Rezoning Transportation Analysis

Petition Number: 2022-147

Date	Description
1-25-23	First Review (IW)
2-22-23	Second Review (IW)

RZ-101

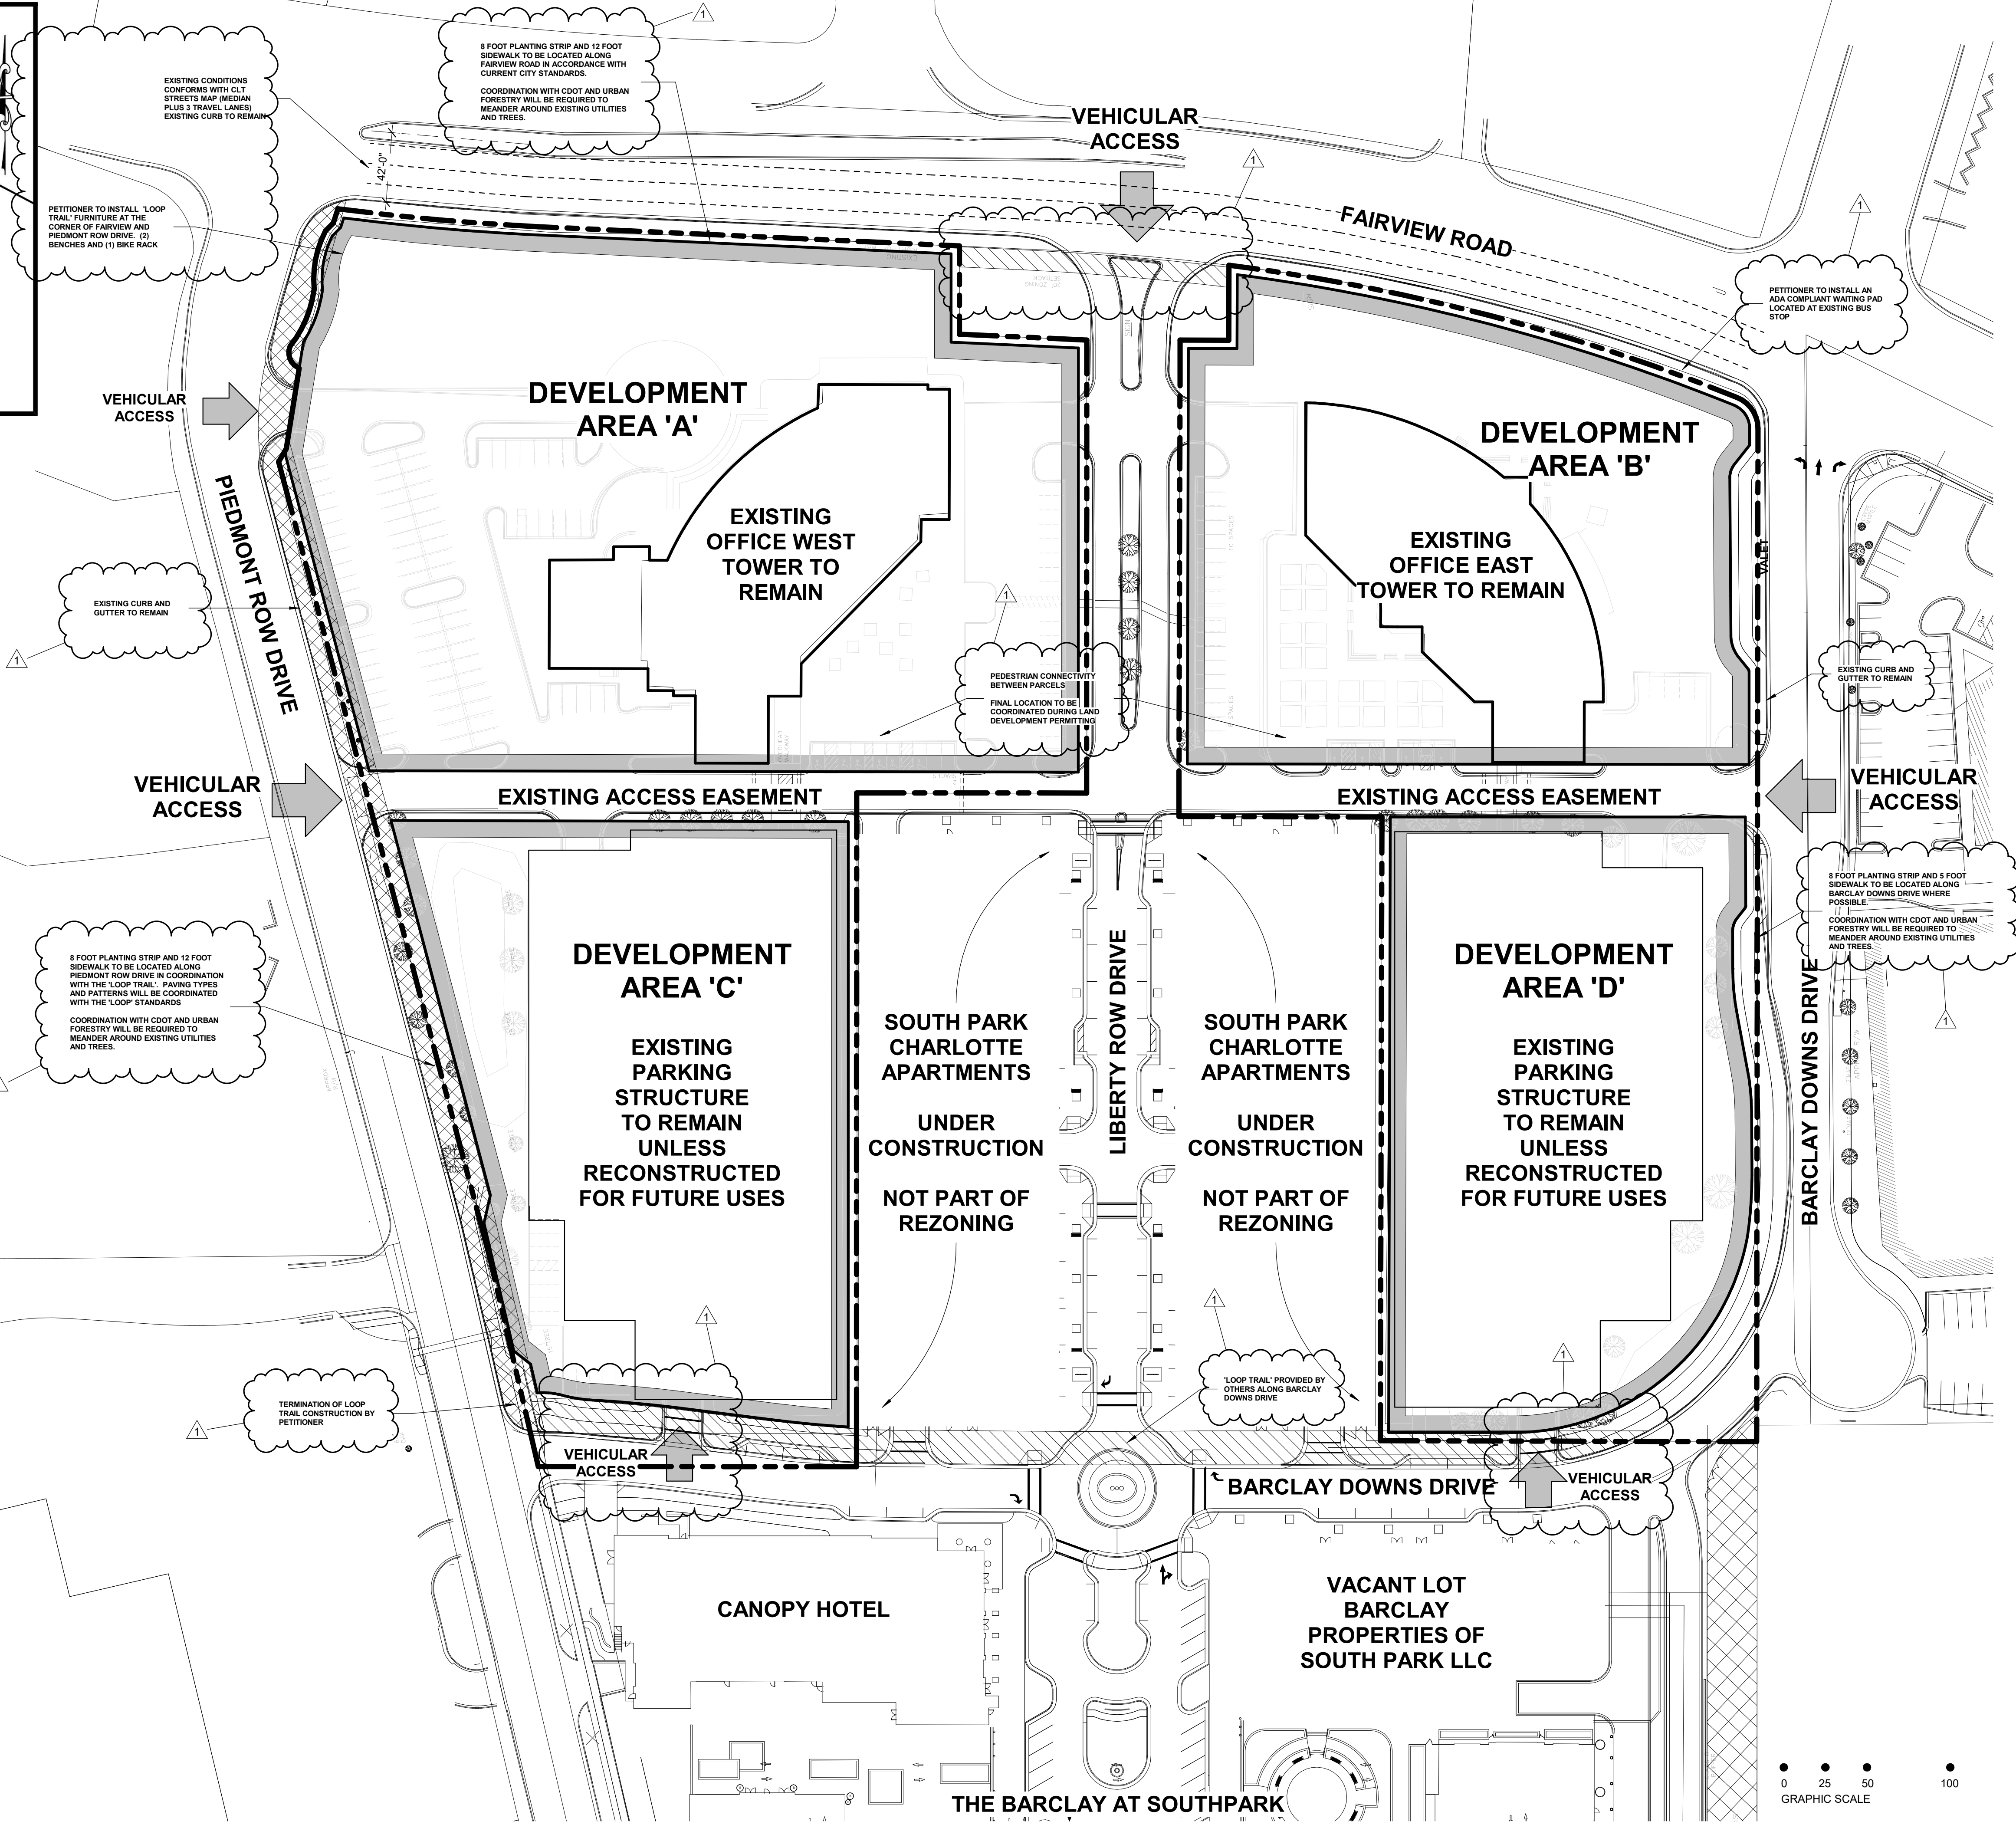
- Outstanding Comment from 1-25-23** Revise site plan and conditional note(s) to commit to dedicate 63 feet of right-of-way from the Fairview Road centerline. The site plan shall label and dimension the right-of-way from the road centerline.

5. Revise site plan and conditional note(s) to commit to construct an 8-foot planting strip, and 12-foot Multi-Use Path on Fairview Road to support the City Council adopted Charlotte Streets map, and to meet the Council-adopted Charlotte BIKES Policy. Multi-use paths maintained by the City shall meet ADA/PROWAG requirements. The site plan shall label and dimension both items from the back of curb and gutter or edge of pavement.

Clarifying Comment 2-22-23: Update conditional note V.e. under Transportation to state “Sidewalks may meander to preserve exiting conditions where approved by CDOT and Urban Forestry.”

11. **New Comment 2-22-23:** In order to comply with federal ADA requirements, the ramps and crosswalk(s) across Fairview Road and Piedmont Row Drive will need to be reinstalled so that the width is the same as the Multi-Use Path(s) the petitioner has agreed to install. A note should be added to install the crossing across Fairview Road with Loop Brand crosswalk markings.
